CITY OF PORTLAND  
 FIRE PREVENTION BUREAU  
 380 Congress Street, Portland, Maine 04101  
 fireprevention@portlandmaine.gov  
 (207) 874-8400

**NOTICE OF VIOLATION AND ORDER TO CORRECT**

<b>Location</b> 40 WEST ST	<b>CBL</b> 063 H004001	<b>Inspection Date</b> 7/31/2017
<b>Inspector</b> Michael Scherb	<b>Inspection Type</b> FP Re-Inspection	<b>Status</b> Failed

CODE:	TOWN: Portland, Me
DATE:	09-26-18
SCALE:	
DESIGNED:	SSA
DRAWN:	SSA
TITLE:	BASEMENT FLOOR PLAN
FILE:	
SHEET:	A-1

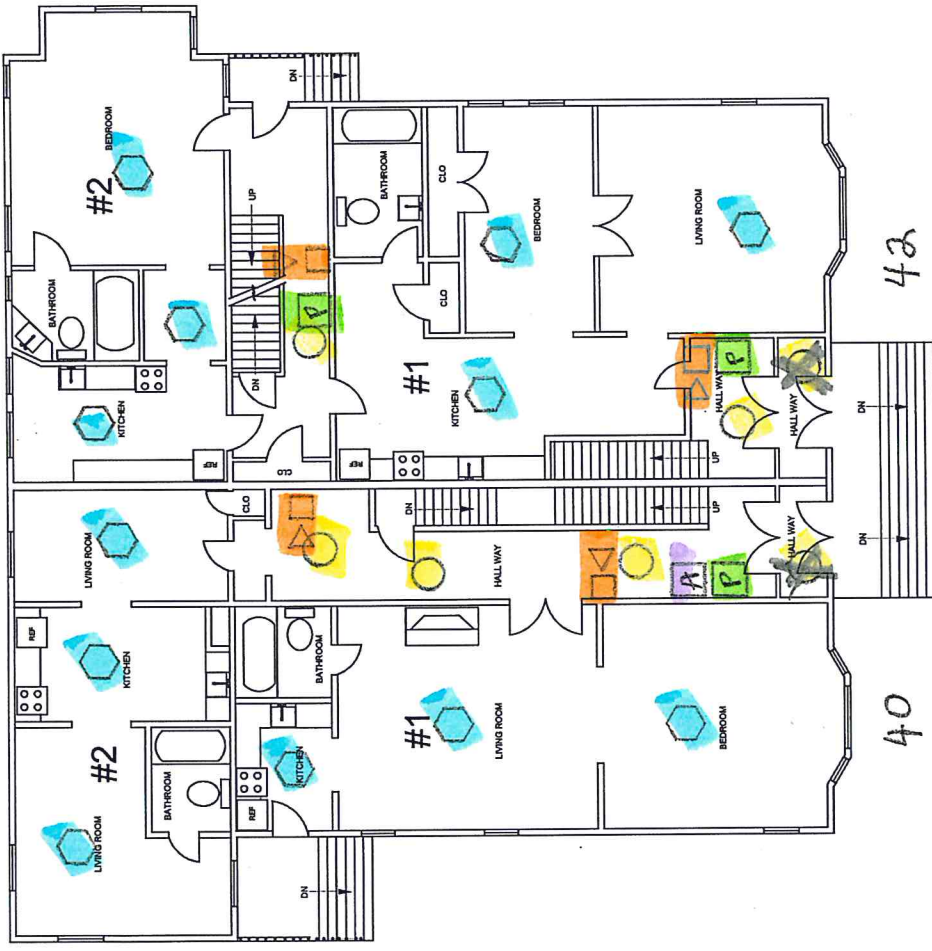
<b>Violation</b>	<b>Proposed Date of Completion</b>
<p><b>NFPA 80- ANNEX D.4 1-HOUR FIRE DOORS ASSEMBLIES REQ;</b> Listings are provided for floor fire door assemblies that are installed in fire-rated floor-ceiling or roof-ceiling assemblies that have been tested in accordance with the methods described in NFPA 288. The listing indicates the fire-rated assembly and the hourly rating (3 hours, 2 hours, 1.5 hours, 1 hour, .75 hours) for which the door can be permitted to be used so that access to the space above the ceiling or to the floor above can be provided without adversely affecting the fire resistance rating of the entire assembly. The listing provides limitations on the maximum size of an individual door opening and the total area of all door openings permitted for each 100 square feet of floor or ceiling.</p> <p>Basement doors need to be self closing fire doors. Door at top of #40 basement stairs should be replaced and door at bottom removed. Door at bottom of #42 needs self closer.</p>
